INTER OFFICE MEMO

To:	S Lettice, N Butler		
From:	Sharon Faulkner		
Subject:	52 Walker St Rhodes – Meriton Development		
Date:	15 August 2010	File No:

Waste Management:

**SWEPT PATH ANALYSIS
OF A 10.2m REFUSE
VEHICLE EXITING THE SITE**

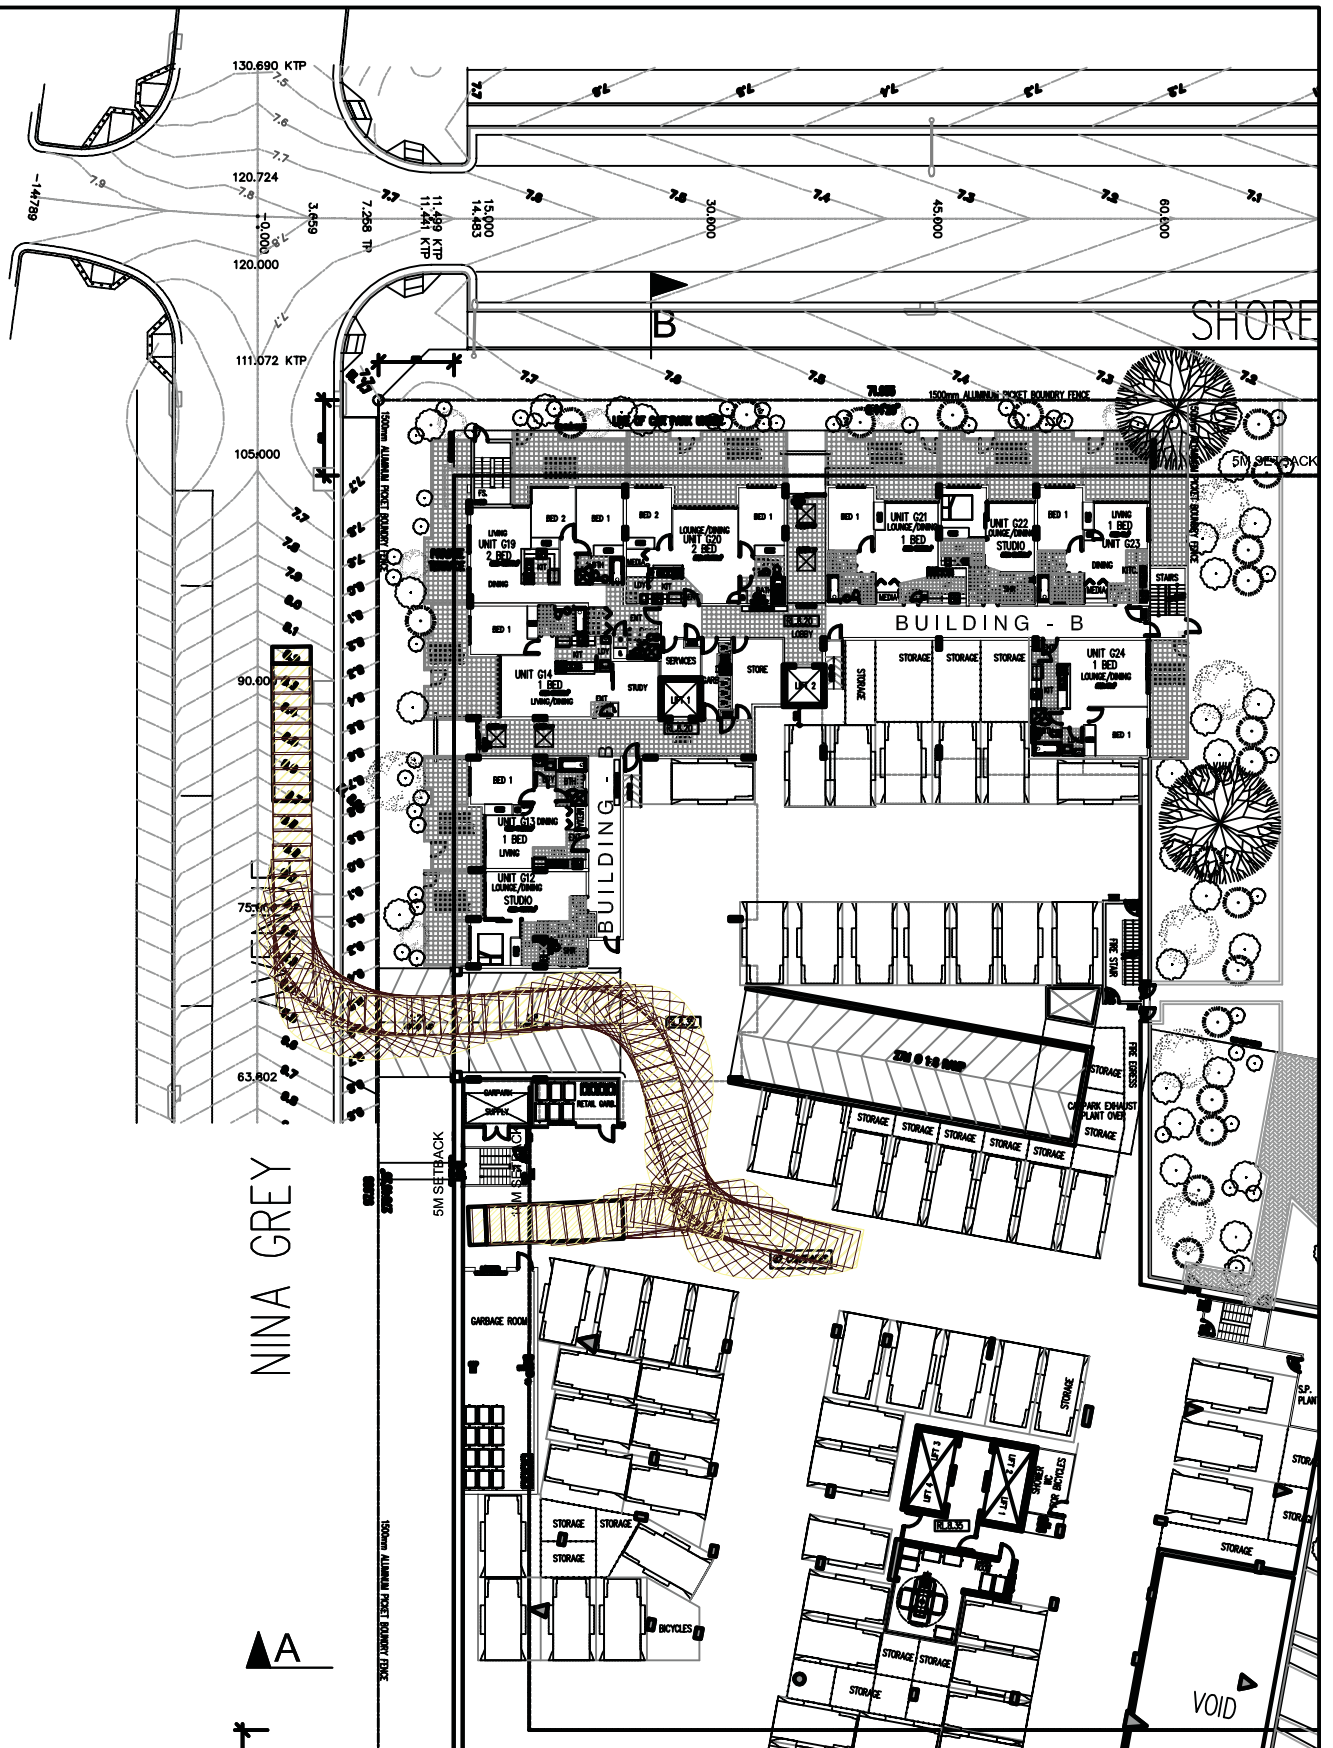
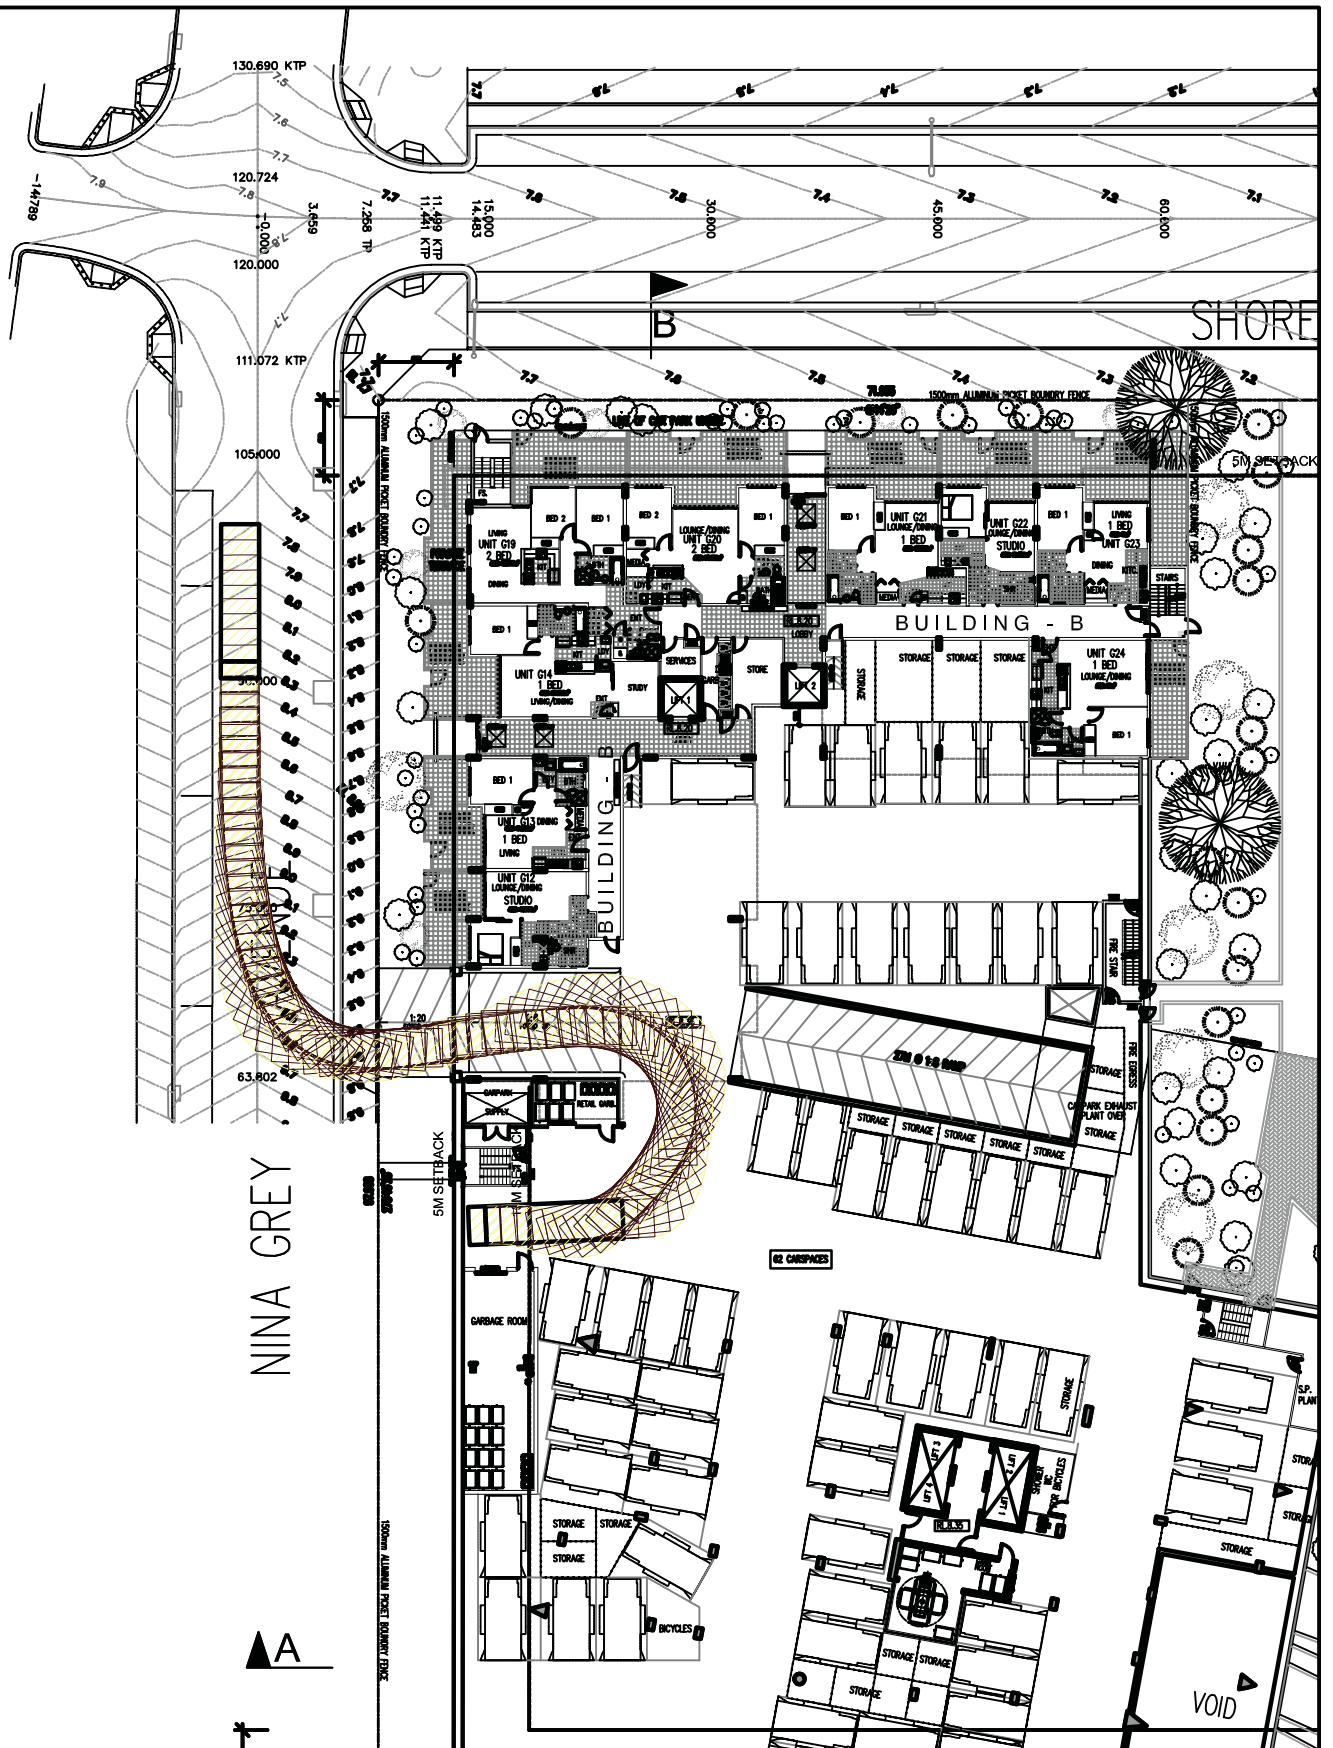
Collection vehicle clearance height 3.8metres

Clearance height is not to be calculated from floor to ceiling with the exclusion of devices attached to ceilings e.g fire sprinklers, pipes etc.

Collection vehicles require clearance height of 3.8metres from floor to lowest device fitted to ceilings
